Application no: H16/0354/95

Description: Proposed covered parking

Location: 44 Double Street
Spalding
Lincs

ACKNOWLEDGEMENT OF AMENDMENT

scale	drawing no.
1-50 1-100	2569-13
APRIL 95	checked

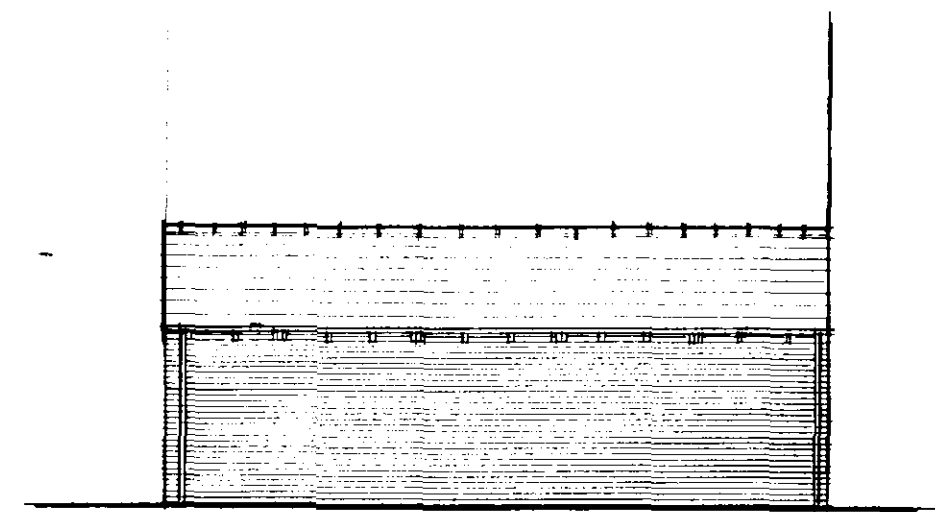
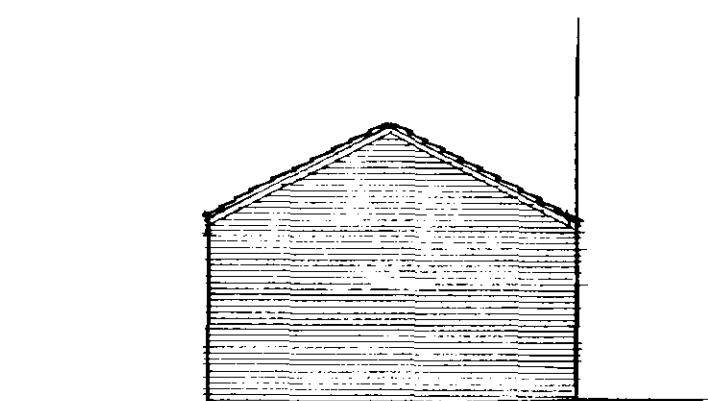
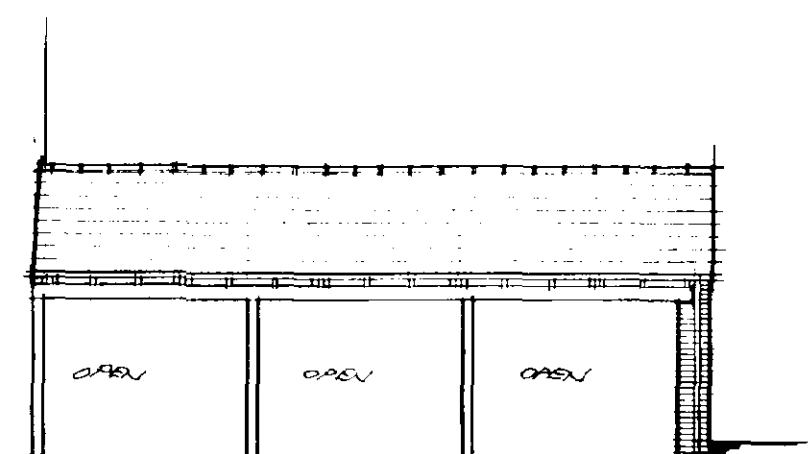
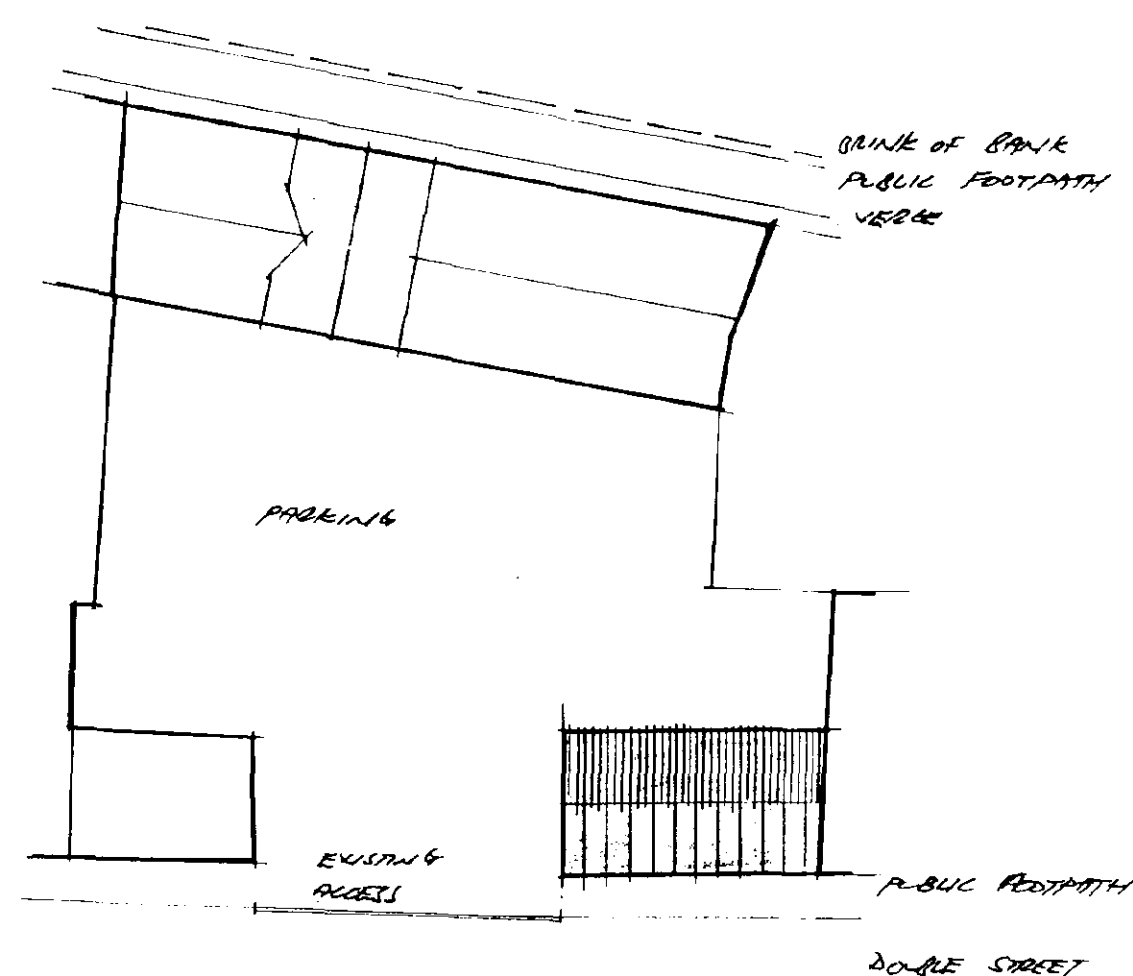
Amendment: Redbank Holbein facing bricks laid in Flemish bond with
light pointing (drawing number 2569-13)

Further to our recent application and Mr. Roberts' telephone call today, we confirm we will build the wall in the same bricks as the offices, but as suggested lay in Flemish Bond with a light pointing.

REDBANK HOUSE FACING
BRICKS LAID IN FLEMISH
BOND WITH LIGHT
POINTING.
